Re: Planning Application 2021/94607
48 Hill Grove, Salendine Nook, Huddersfield

FRONT ELEVATION 1 :50

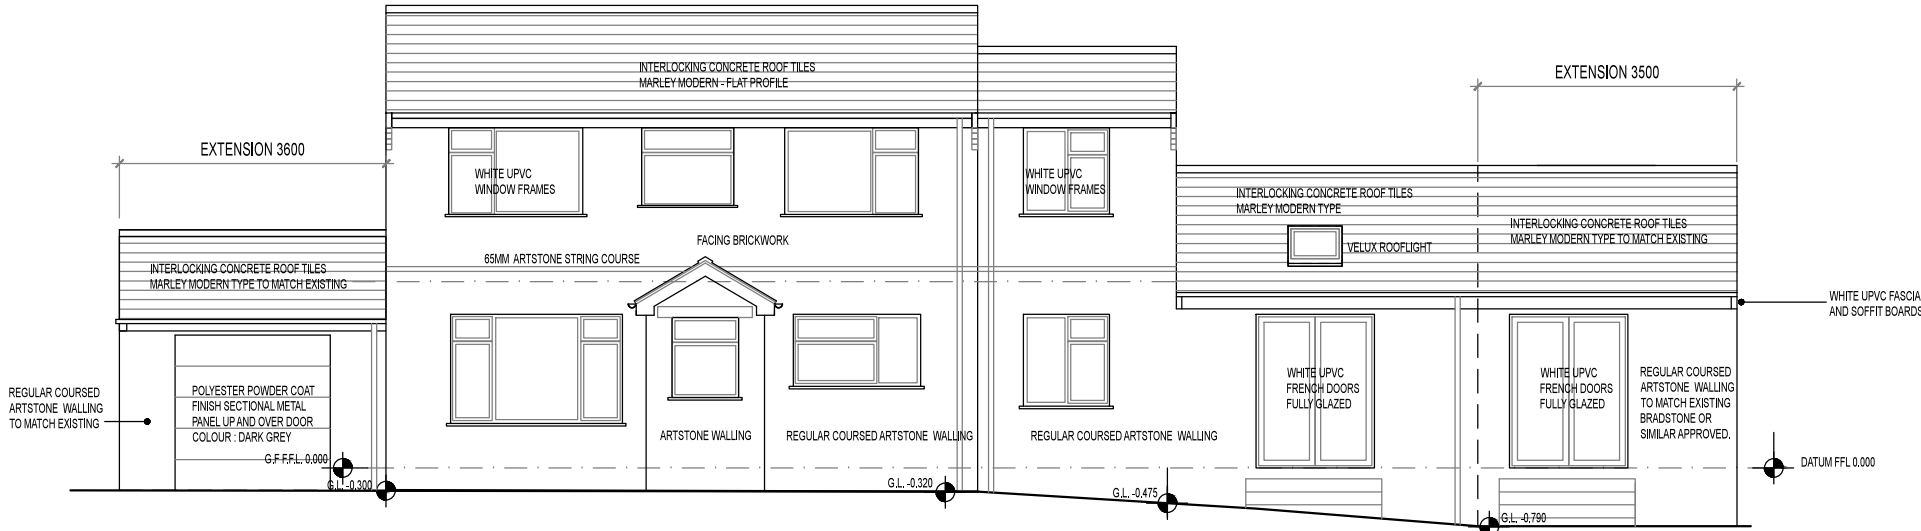
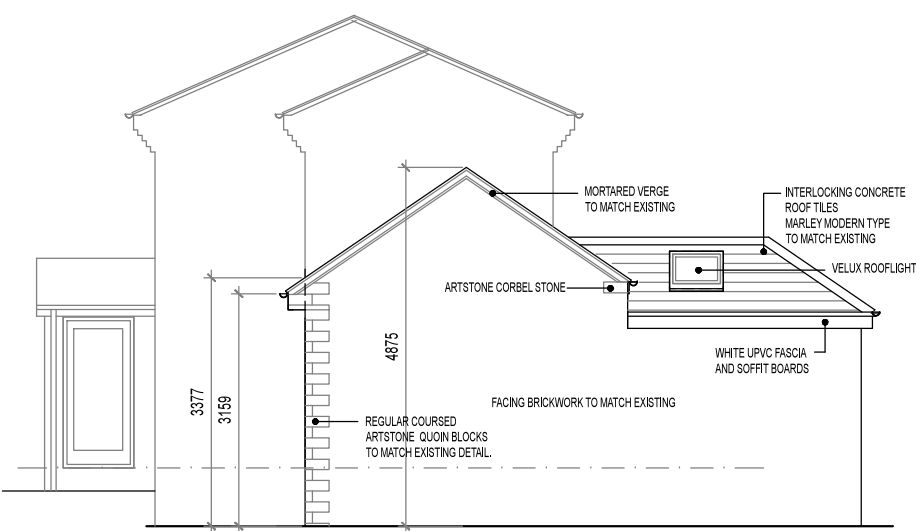
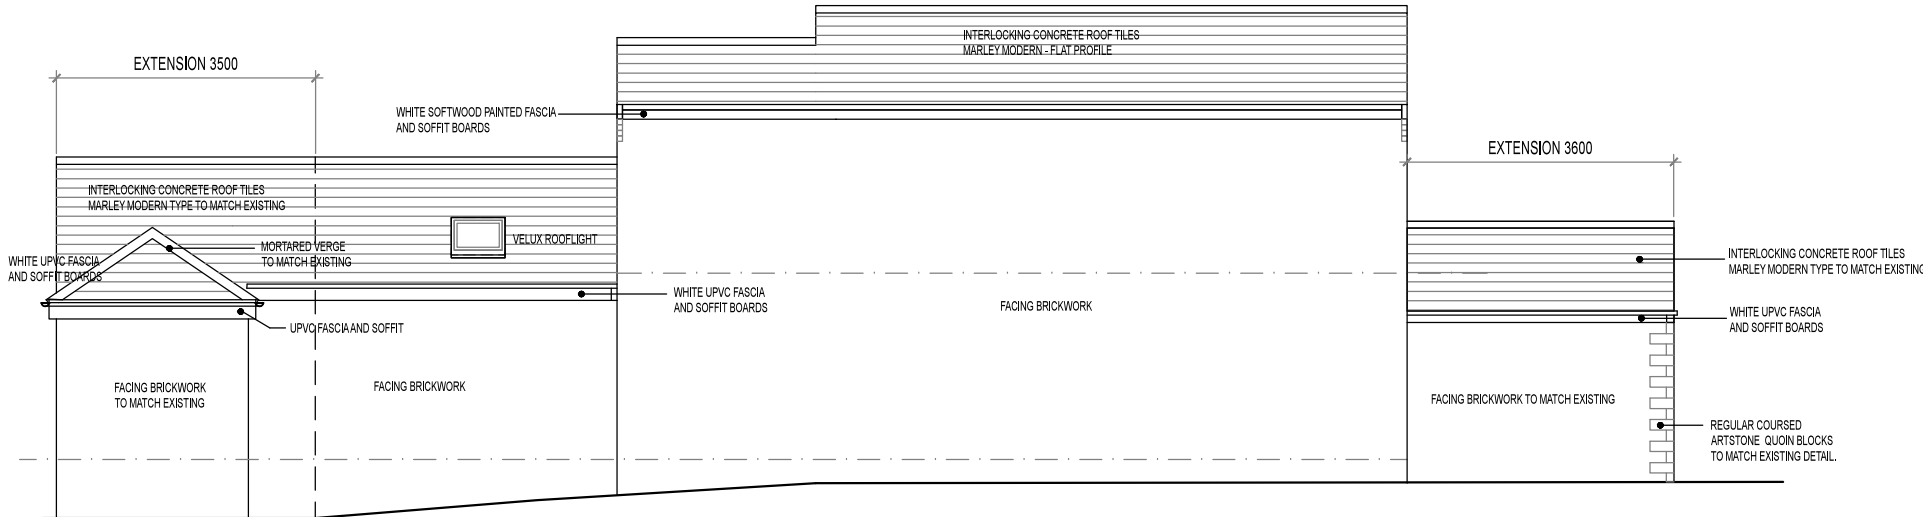
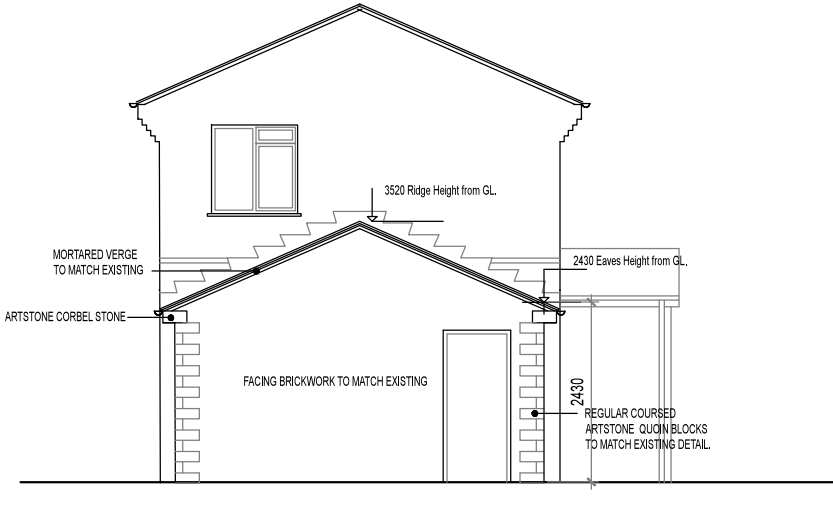
1. The proposed extension to #48 will leave no space in three sides.
2. The proposed extension would destroy the essential qualities of the locality. The estate consists of regular, rectangular, well proportioned properties and this proposal ignores these qualities by creating a misshapen ill proportioned building mass, the estate is made up of houses where the short elevation faces the street, this proposal would create another wide house, out of character with the originals.

3. The existing house has a relatively balanced facade, this detail which is shared by neighbouring houses, will be unnecessarily vandalised by the extension characteristics.

4. The existing properties have a sense of balance and composition. This proposal utterly ignores the original building scale and composition. There is no attempt to harmonise or even add to the existing house in a sympathetic manner which respects both the existing house and the neighbourhood. The front elevation of the proposed building displays two sets of French doors in addition to the front door, giving the appearance of a House of Multiply Occupancy. This proposal is not a neighbourly building.

GROUND FLOOR PLAN 1 : 50

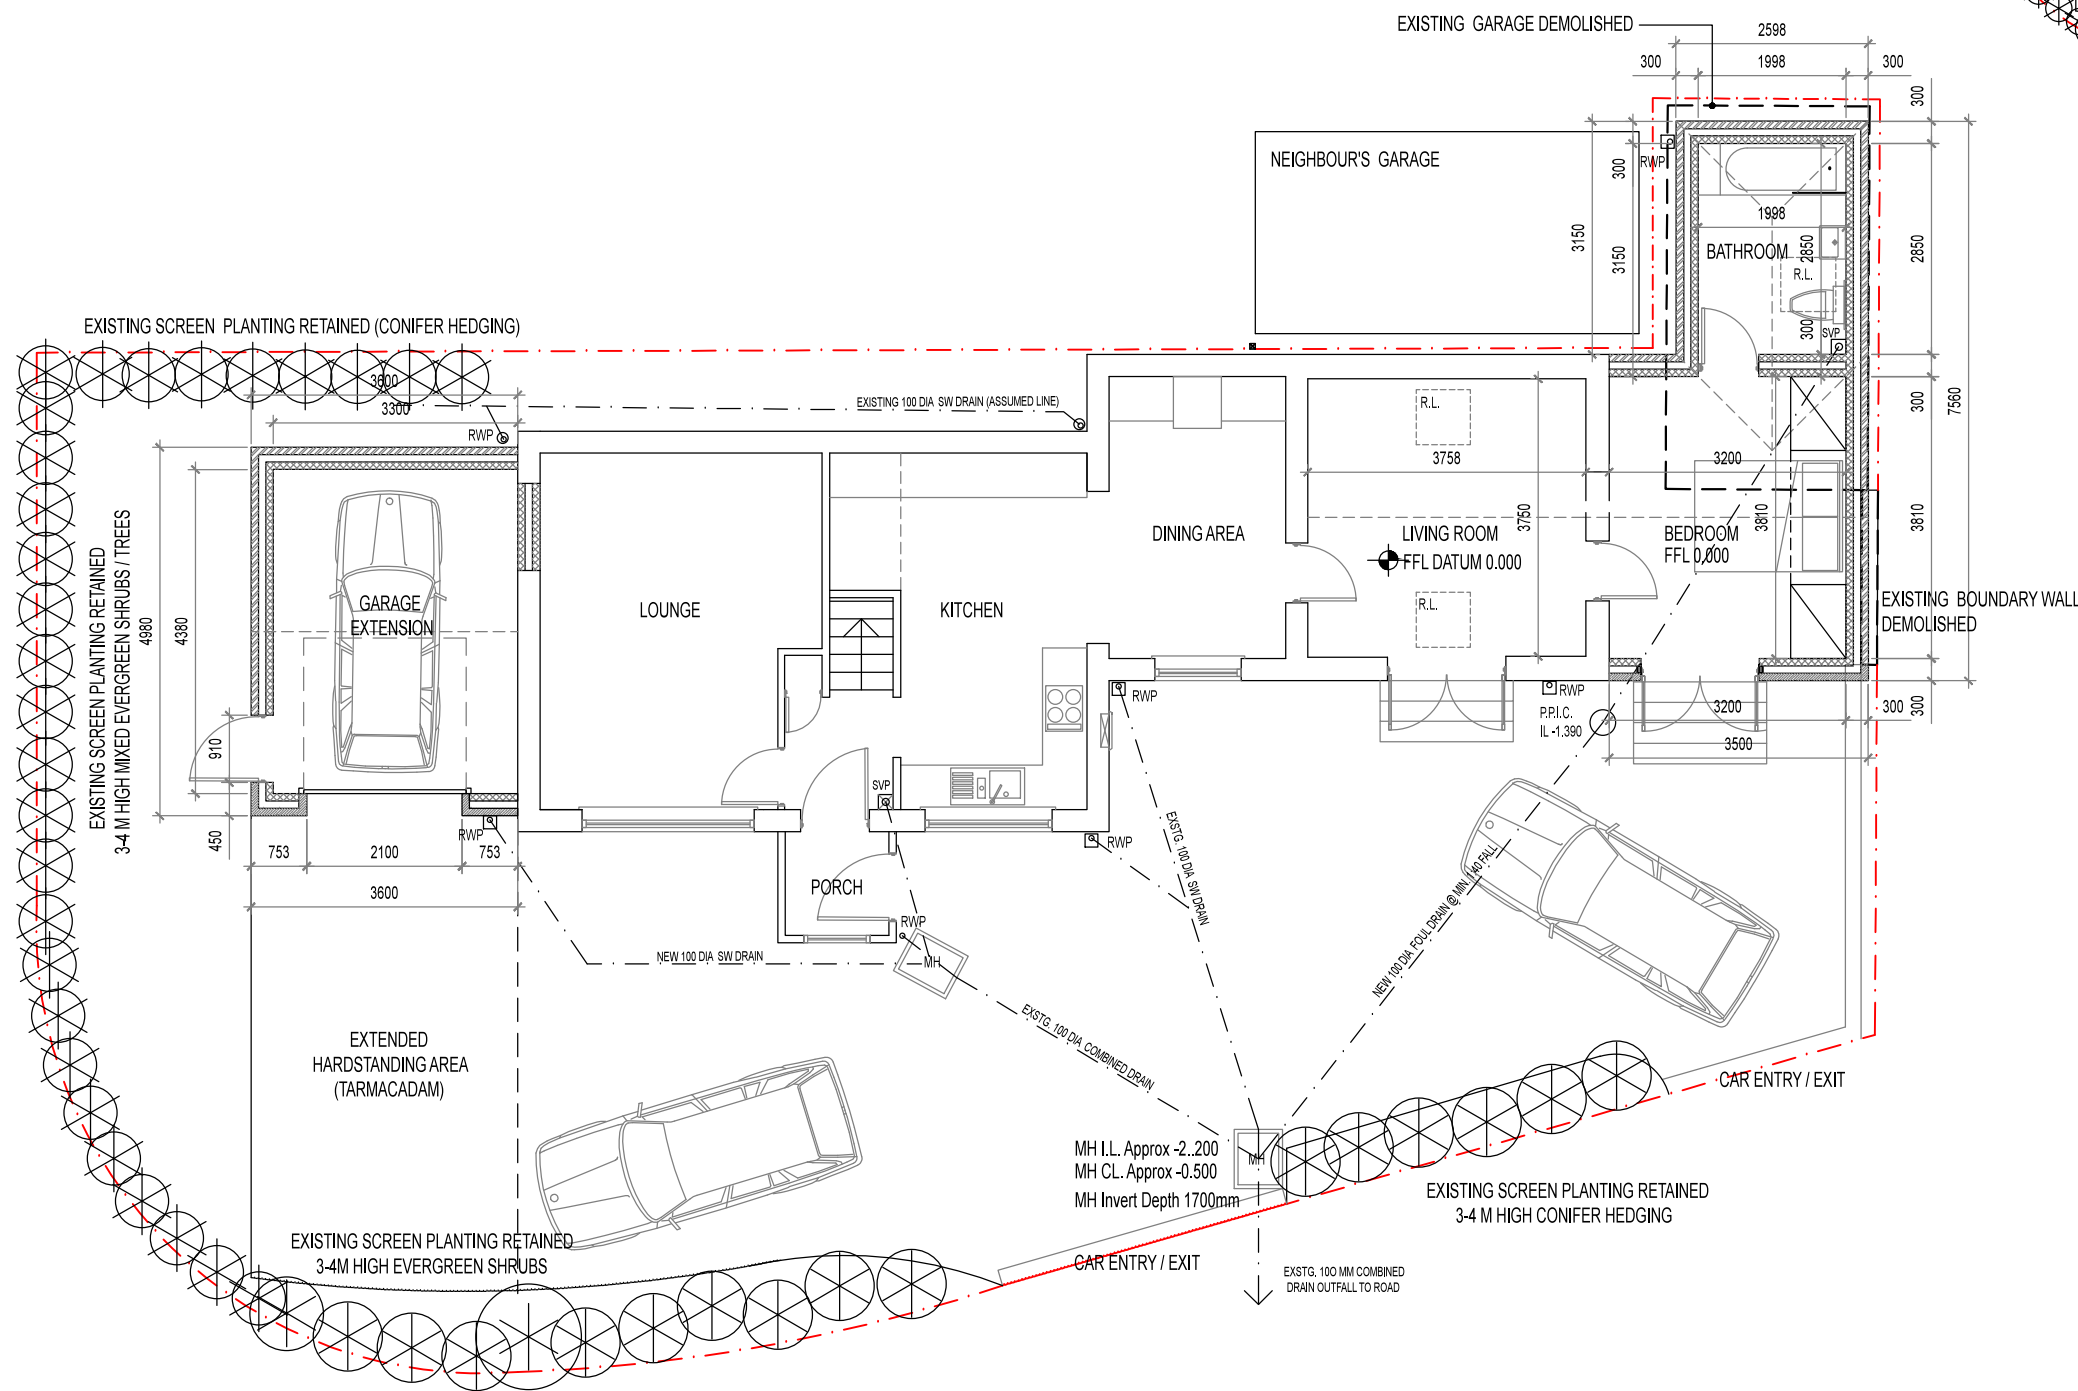
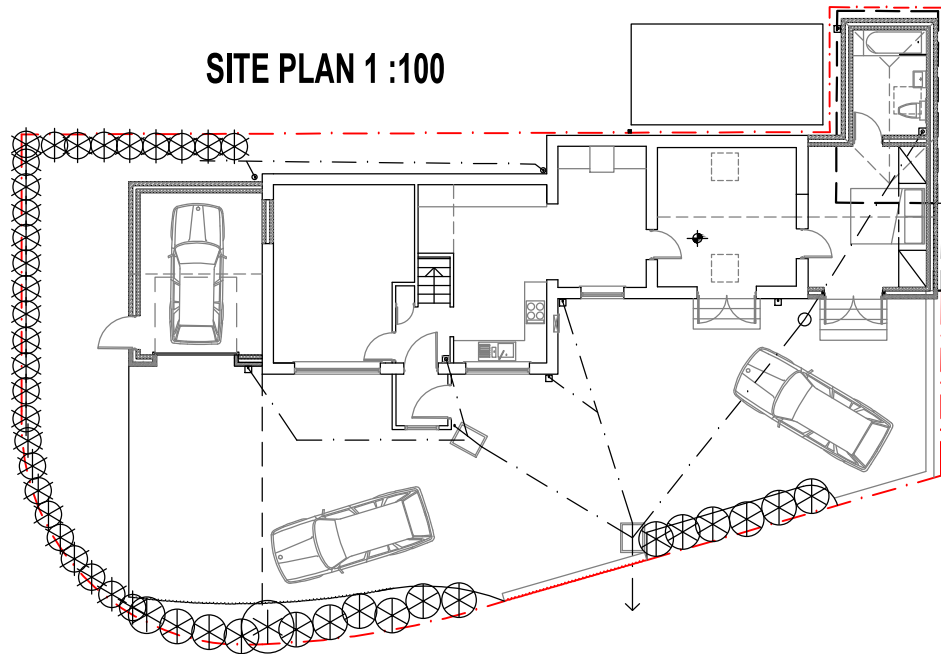
5. The current building restricts our ability to maintain our garage and would certainly impede any maintenance on 48 Hill Grove. We would be losing the openness to the south

of our garden, we would not only lose sunlight to our main garden but it would be a considerable loss of enjoyment. The building would be too close to our boundary and would be oppressive.

6. The proposed extension is out of proportion to the original building and constitutes a gross overdevelopment, The latest extension, the third and fourth to this particular property would make it three times the size of the original build.

8. The 'existing Green Planting Retained (Conifer Hedging)' was planted on our boundary and is not maintained by the occupants of No.48 but by ourselves. The said hedge obstructs the view of the pavement when exiting our driveway and requires somebody to stand at the top of drive to warn pedestrians coming around the corner of the fact that a vehicle is exiting. This represents a Health & Safety Hazard. We have previously requested the reduction in height of the Conifers and this did not meet with the property owners.

9. The plans indicate the tarmac/paving of the property, front, side and the building on all sides to the edges of the property, we feel that this will cause water/rain/snow run-off onto our property as well as onto #46, causing both properties to become waterlogged.
